Wayne R. Dashfield, PE

June 29, 2020

Re: Footing outside Middle Third
325 Southern Place
Lillington, NC

To: Harnett County Inspections

TYPICAL WALL: 8" BLOCK W/ 18" X 10" FOOTING
 3- 2 X 10'S GIRDER
 2 X 10'S 16" OC JOIST

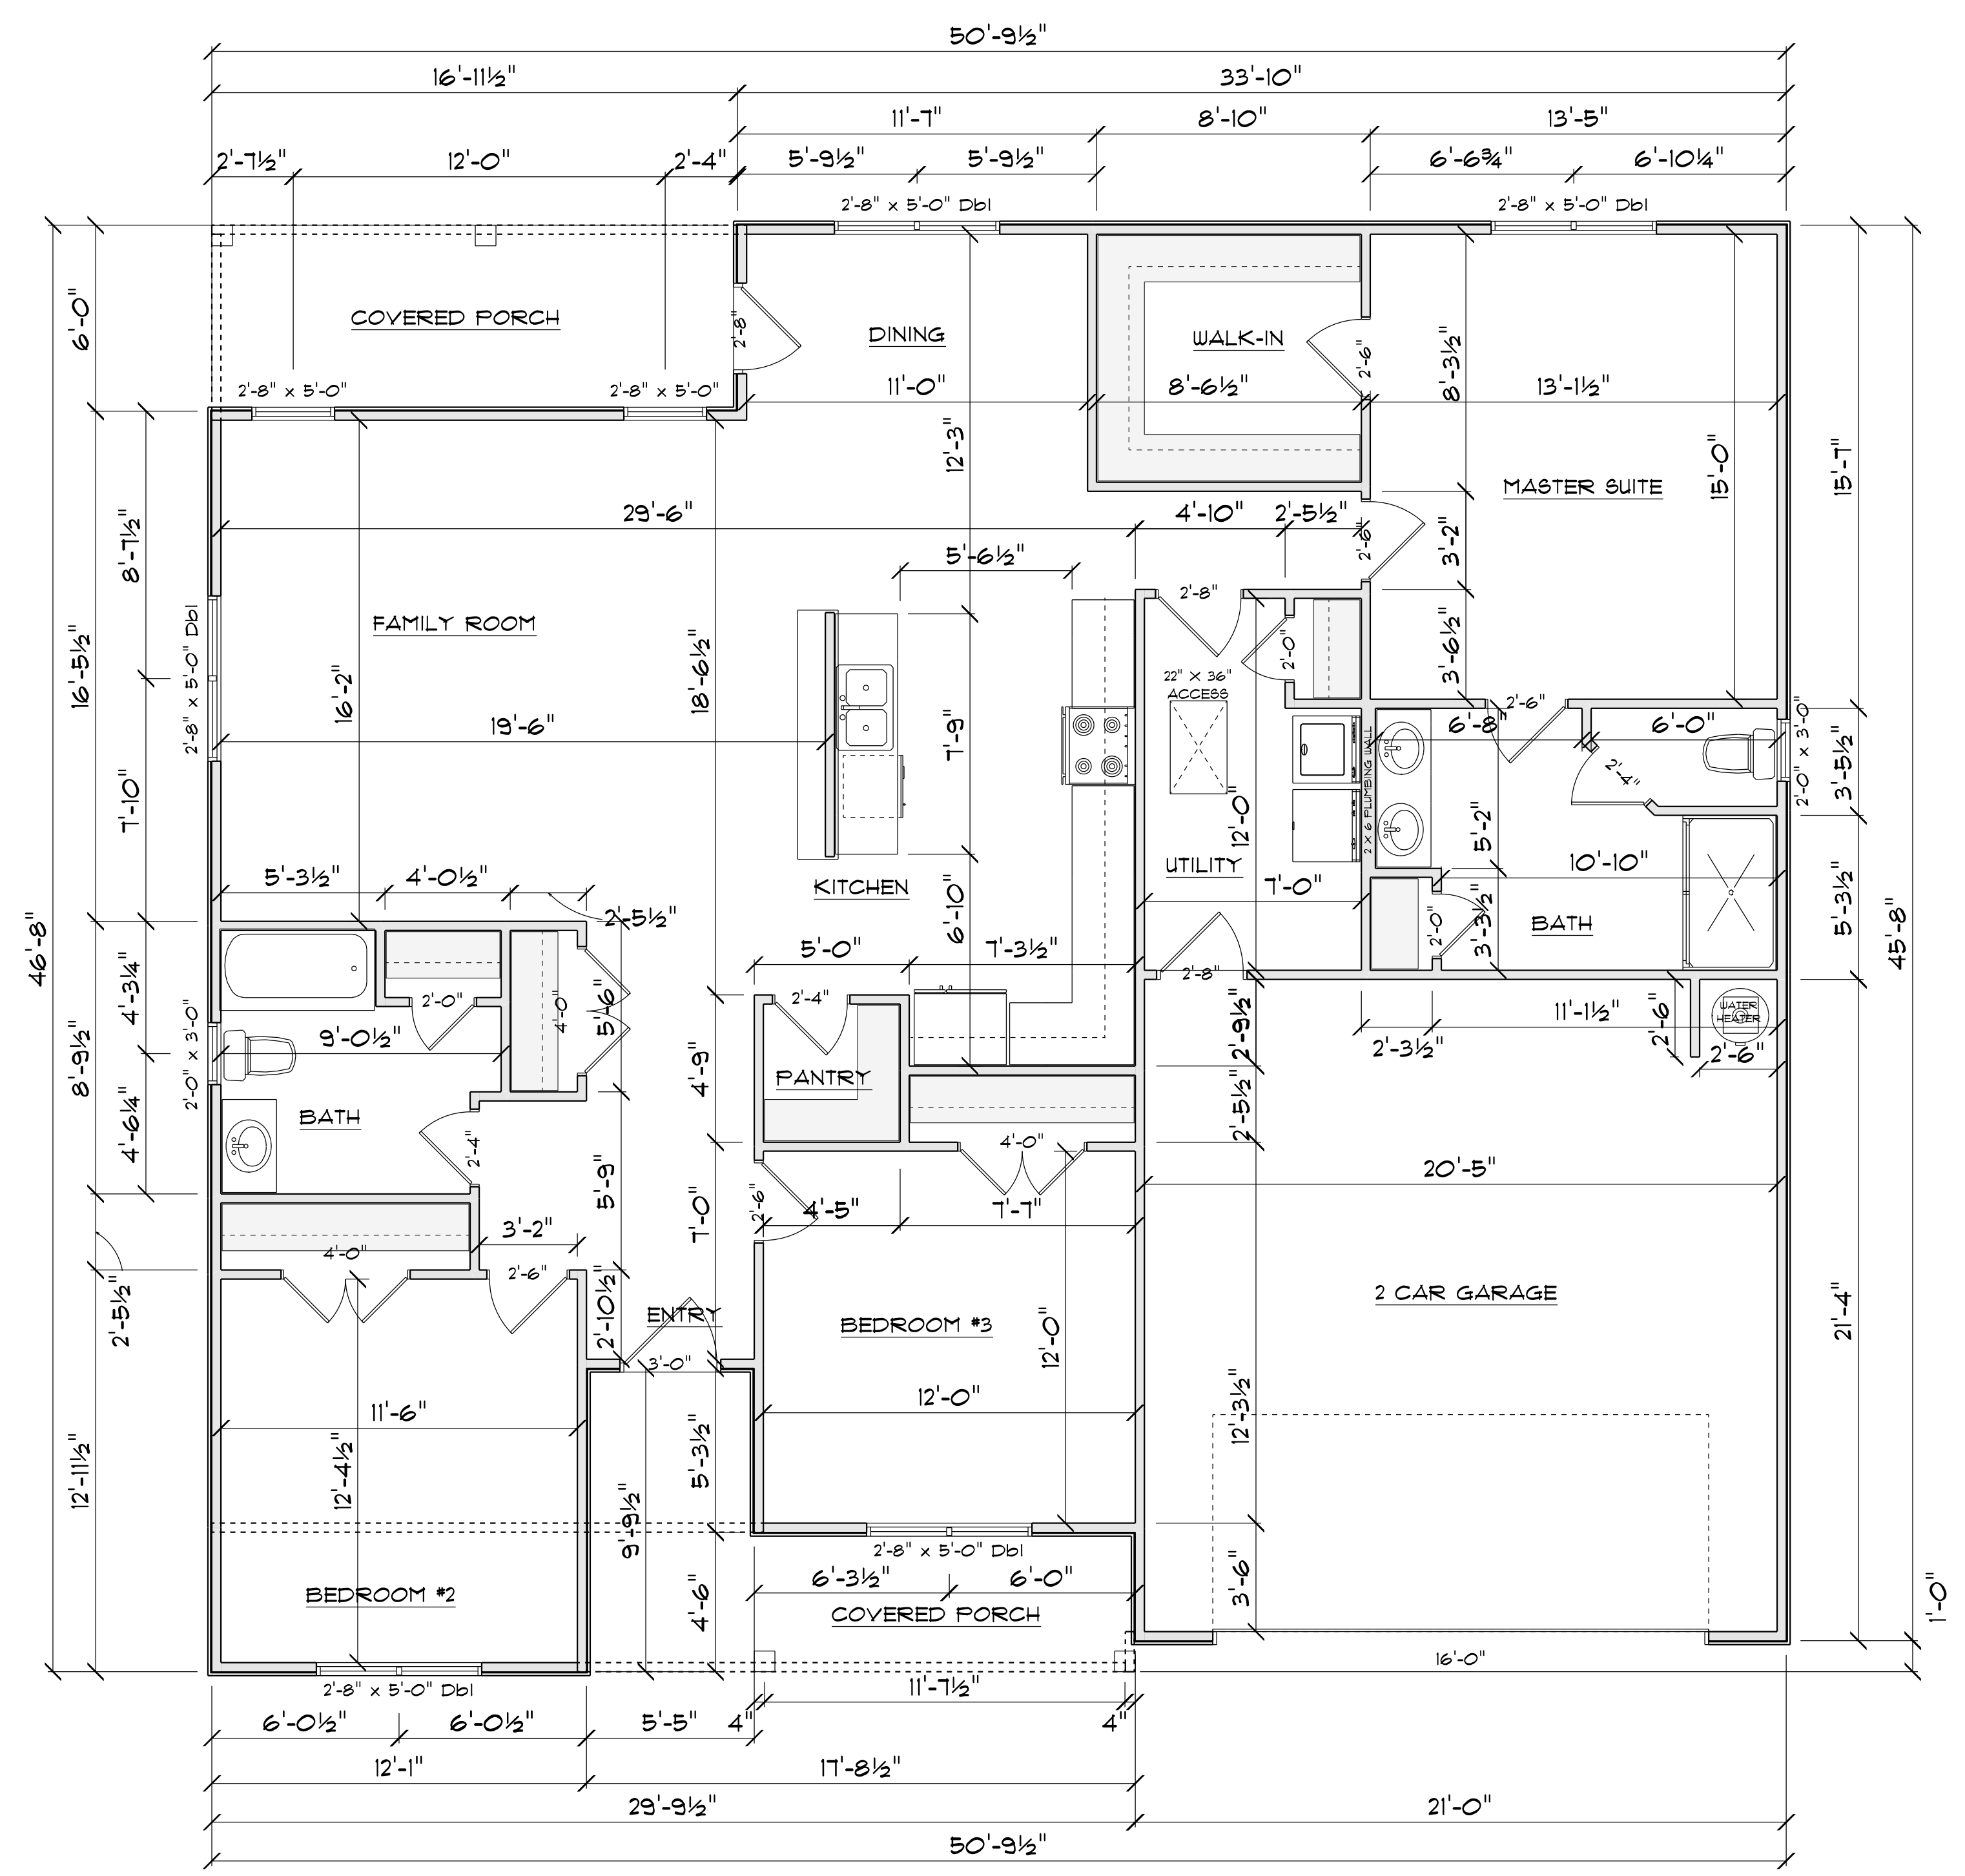
On June 24, 2020 I made an onsite visit to 325 Southern Place located in Lillington, North Carolina. The purpose of this visit was to inspect the pier foundation footings in which the resultants were outside the middle third of the footing.

It is a good practice, in general to have the resultant located within the middle third. However in a foundation on a very incompressible soil or a low loading such as in this case, the resultant can be allowed to fall outside the middle third.

I will certify that the resultant loading will not induce over turning or excessive settlement on sections of the footing. If I can be of any more assistance, please feel free to contact me.
